A46 Newark Bypass

Statement of Common Ground with Historic England

**The A46 Newark Bypass
Development Consent Order 202[#]**

**Statement Of Common Ground with
Historic England**

- NOTES**
- THIS DRAWING IS TO BE READ IN CONJUNCTION WITH THE DRAFT DEVELOPMENT CONSENT ORDER AND ACCOMPANYING APPLICATION DOCUMENTATION. (TR010065/APP/3.1).

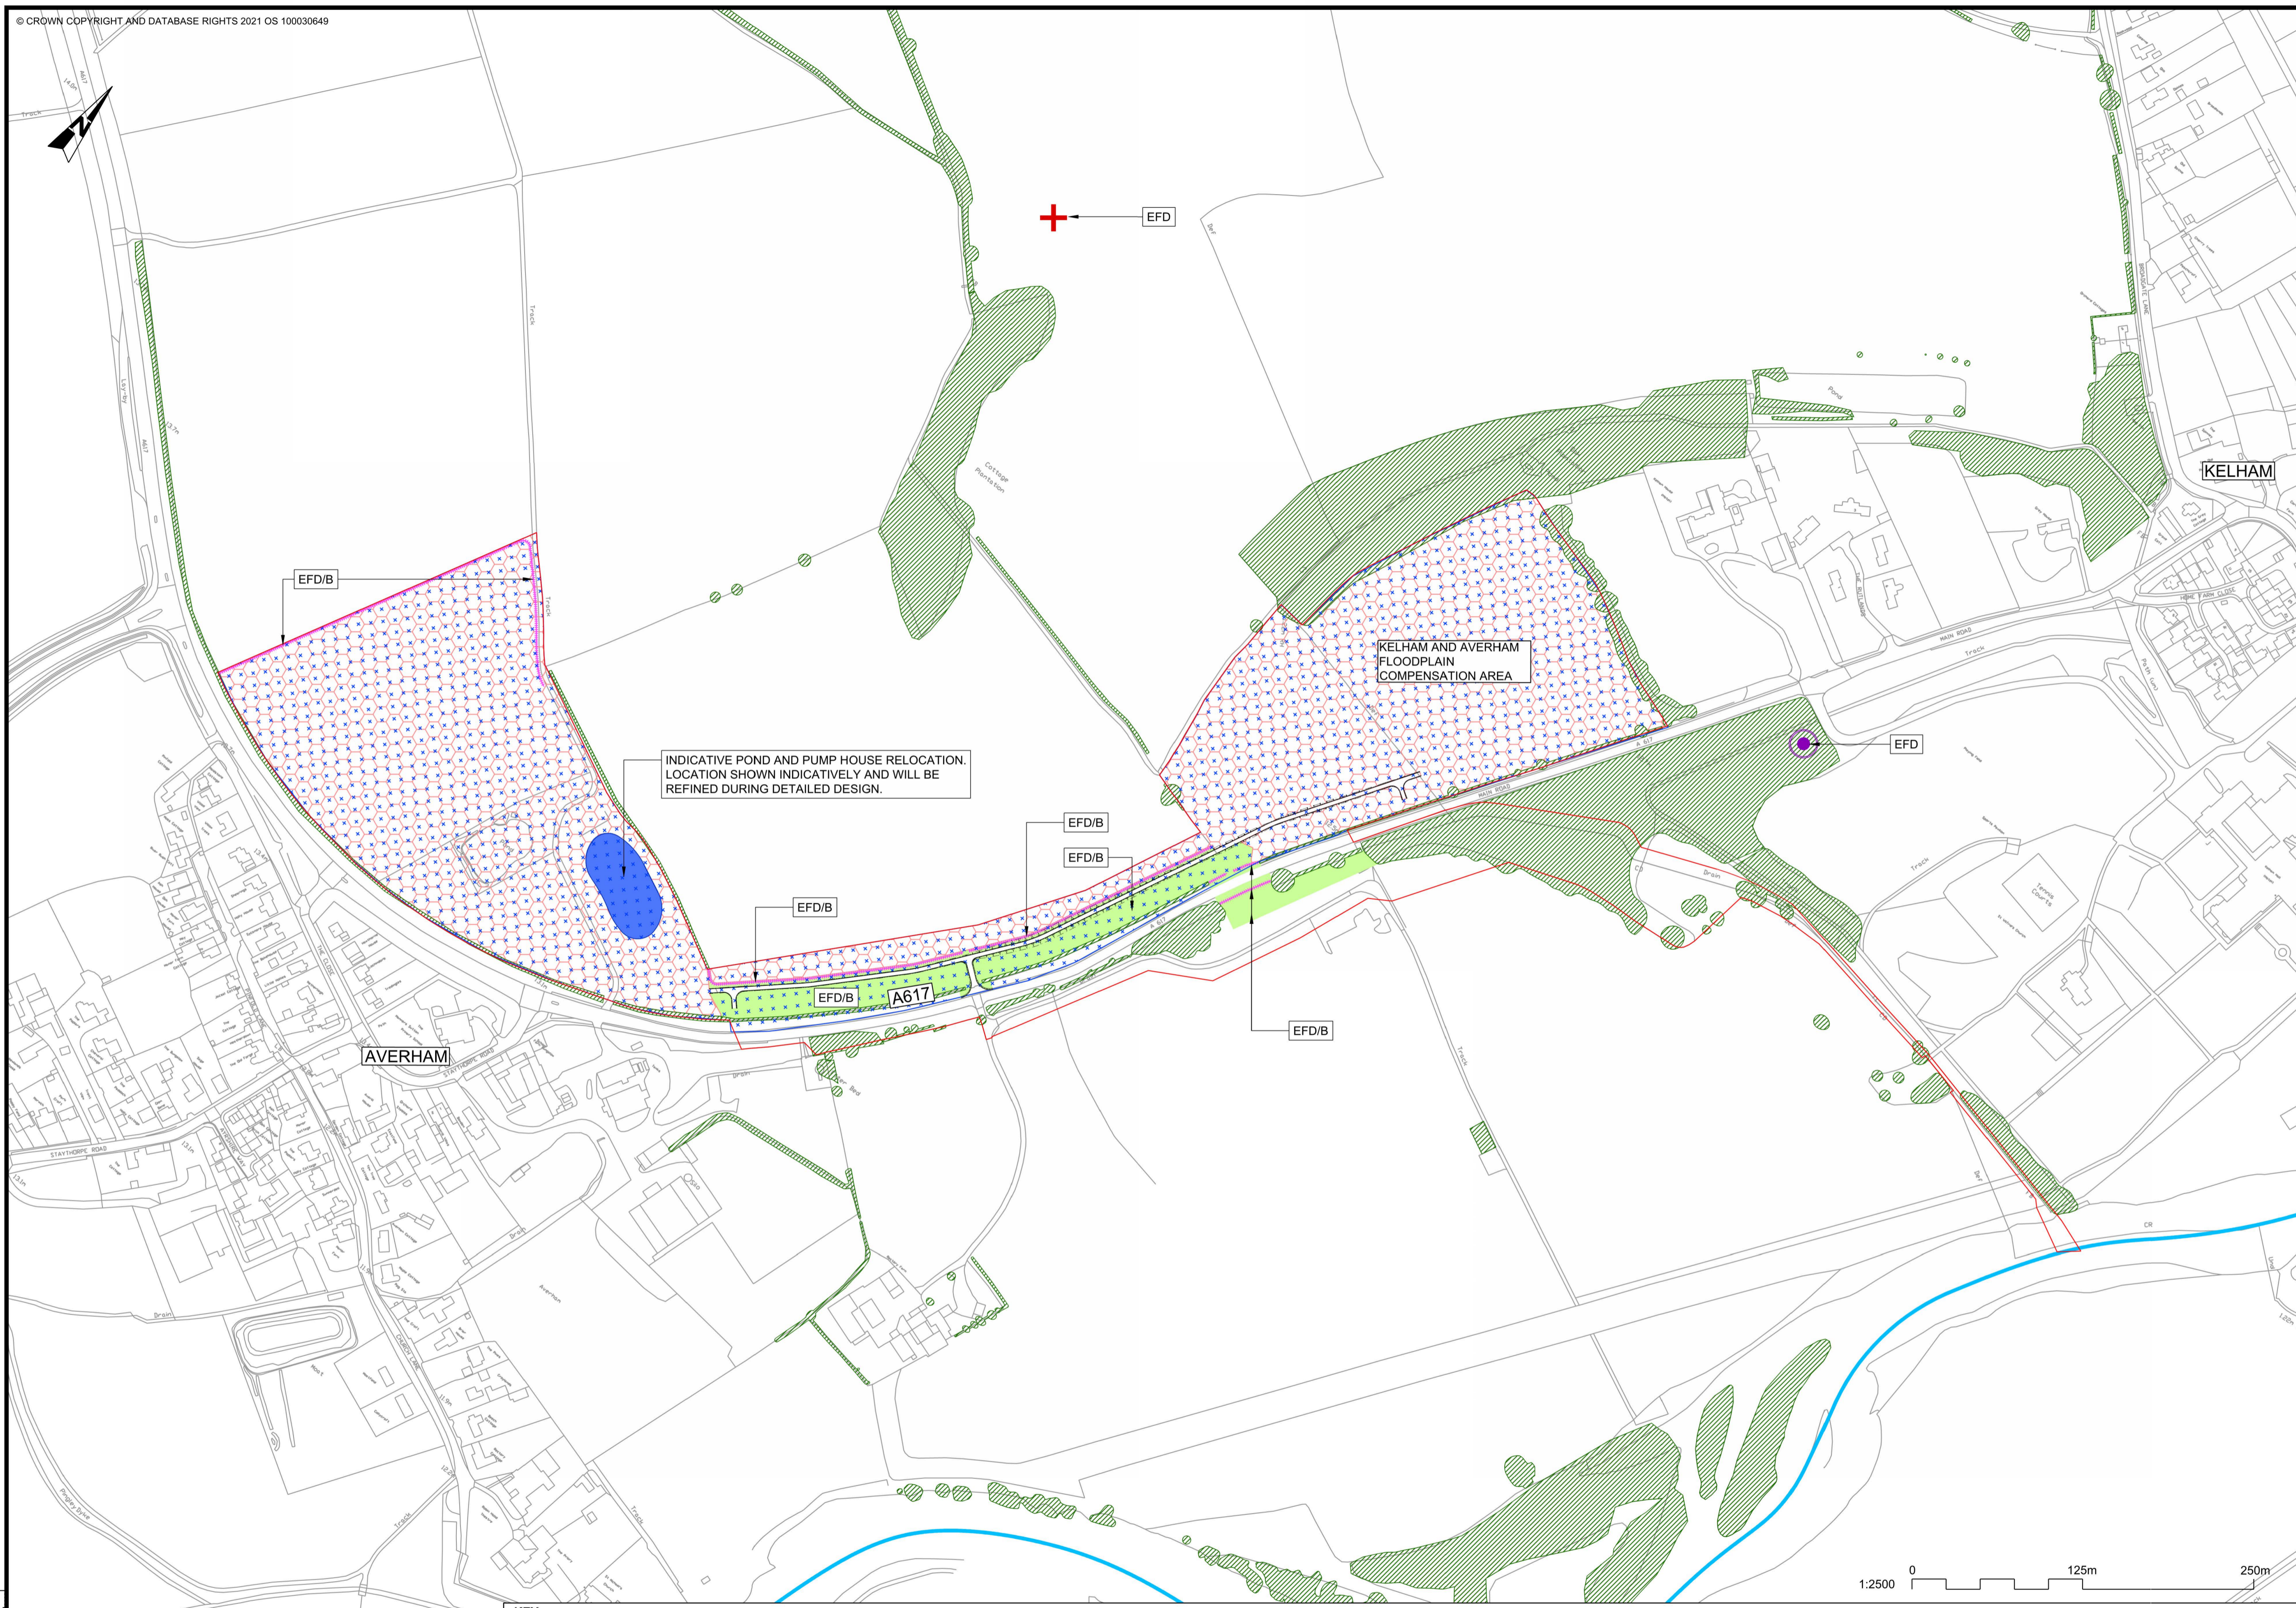
13.	Langford Hall – new approach road and entrance gates	Figure 2.3 (Environmental Masterplan) of the Environmental Statement Figures [AS-026]	<p>Meeting with Historic England 11/10/2024:</p> <p>Understand rationale behind linear route for new driveway between new proposed entrance and location where it meets the existing driveway. This route avoids historic copse of trees at original end of the driveway. The direct line approach meets the existing driveway at a natural break in the trees.</p> <p>Agree that there is no clear rationale, or extra benefit to creating a faux curvilinear approach in this location.</p> <p>Agree that meeting the existing driveway at the proposed location, ensures that the gradual 'reveal' of the main house is retained and conserved.</p> <p>Discussed requirement for new entrance to 'speak to' the architecture of the Langford Hall, and to serve its purpose of ensuring visitors and passers-by that this an entrance to an important property.</p> <p>Also discussed the importance of the design of any gates, piers, railings, to be a 'foretaste' of the architectural style of the main house – not detailed as a pastiche of work elsewhere, but – appropriate in scale, neo-classical proportion and design, of good quality, natural materials, including brick, stone, lime mortar, estate railings etc, matching the pallet of the house to ensure quality of finished design, and its execution by an appropriately skilled specialist (sub) contractor.</p>	<p>Routes to the north of the proposed landscape bund in order to join at location of lodge were considered but had no clear rationale and would result in impacts to habitats through destruction of a historic copse of trees.</p> <p>Proposed linear route from existing field gate, directly to natural break in historic tree-line is a clear choice, and ensures sense of reveal and arrival afforded by existing driveway is retained and maintained.</p> <p>Proposed new driveway will have avenue tree planting, in line with existing parkland/estate entrance characteristics, as outlined in Figure 2.3 (Environmental Masterplan) of the Environmental Statement Figures [AS-026].</p> <p>The Applicant agrees with Historic England's position with regards to design and detailing pillars/gates/railings for the entrance.</p>	Agreed	11/10/2024

Regarding the detail drawings / materials for the new gateposts and drive at Langford, [REDACTED] please may you get in touch with [REDACTED] on this once the detail is available, to ensure the proposals match the discussions with [REDACTED] on 11/10/24 (see Row 13 of the SOCG).
